Your Ref :
Our Ref : LU/181/17/NMA

Application for a non-material amendment following a grant of planning permission LU/291/15/PL to change the east & west first floor windows, reduce size of patio doors & replace boarding with white render.

1A & 1B Northway Road, Wick, Littlehampton,

tp727/12a

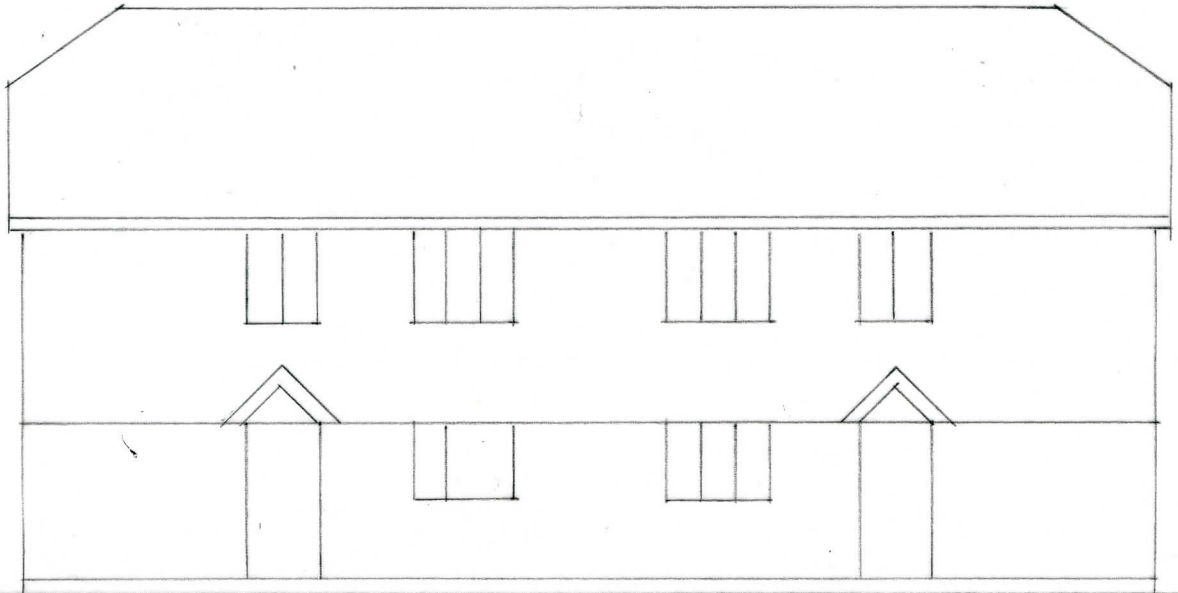
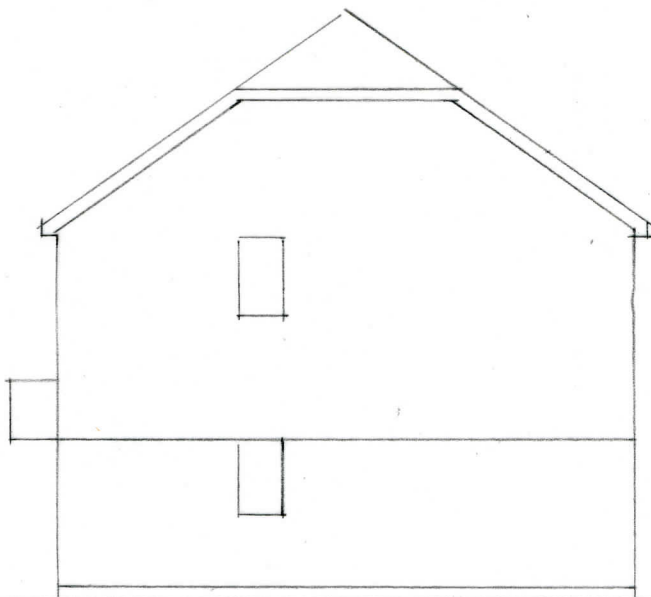
I refer to your recent application for a Non Material Amendment. From the information submitted I am able to take the alterations proposed namely changing east and west first floor windows, reducing size of patio doors and replacing approved first floor boarding with white render as a Non Material Amendment to LU/291/15/PL.

Accordingly drawings Elevations 1 tp727/12a and Plan tp747/10a and First Floor Plan tp747/11a have become the approved elevation, first floor and layout plans for planning permission LU/291/15/PL.
